Submission
Geoff Hood

Overland - Orange Grove Sun Farm

Misleading use of a Floodplain Management Plan Data

Figure 2 Site Layout, Locality and Drainage Features

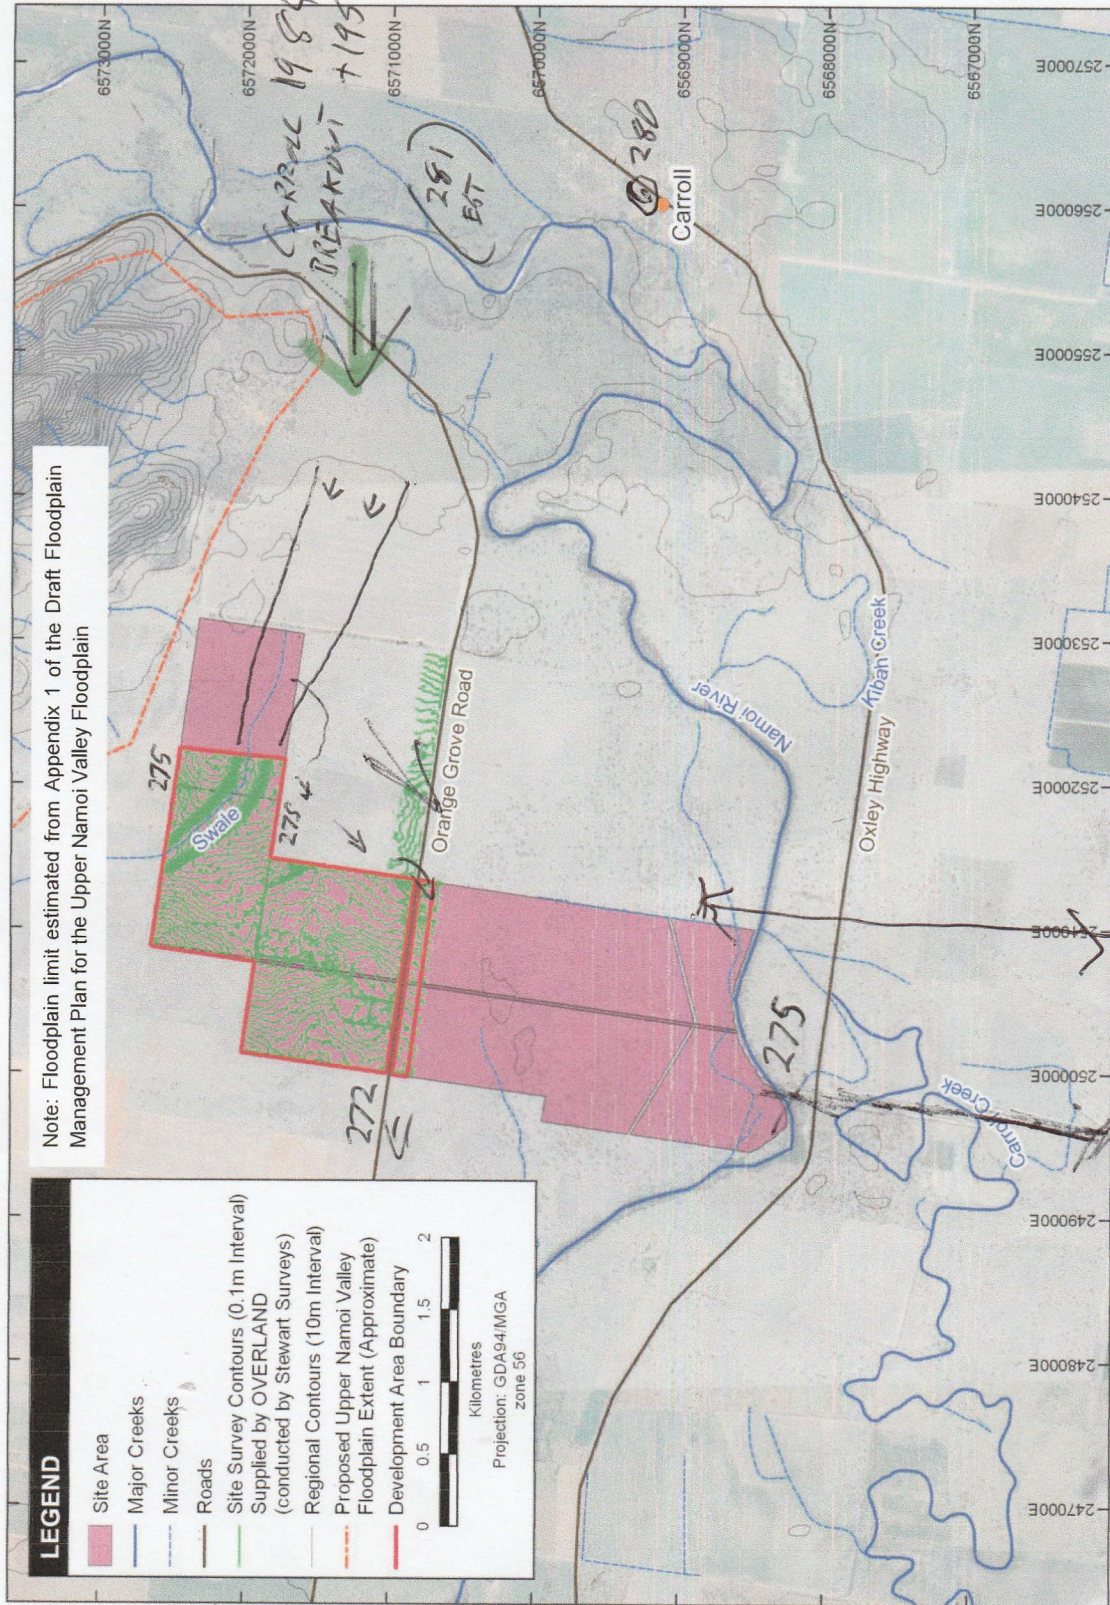
HEC actually acknowledge this on Page 14 in the second paragraph "Upstream of Carroll, the river valley widens and flood flow breakouts occur from the Main Namoi River Channel. " Yet there is no on ground survey to confirm what happens in this vicinity, note - there is flood scour across the Orange Grove Road towards to proposed solar development, indicating previous flood flows There is no modelling of what would happen with flood impacts against the Solar Farm perimeter chain mesh security fence

ON page 16, point 5. HEC acknowledge a depression SWALE through the development footprint, yet the developer put a chain security fence across the flow so to speak, across a possible watercourse If there was allowance for up to 897m/s flood discharge (As per the Carroll Boggabri Flood study) of flood flow through the development, with either no fence, or no fence and a floodway no development incorporating the SWALE, then my objection may change

The summary at the end Page 16 is incorrect, and selectively corrupt, by selectively measuring river heights below a major breakout. To Say" the proposed development (with complete perimeter chain mesh security fence, across a SWALE, mapped as a first order stream? - breakout floodwater) should not impact on the relevant large design flood". is not the truth. Hence my objection

Would be best to redesign, partially remove fence, or incorporate a floodway, The development could cause Major Flood - floodwater to run down the Orange Grove Road past Rivergrove, if the complete perimeter fence was blocked by debris and stood erect during the event.
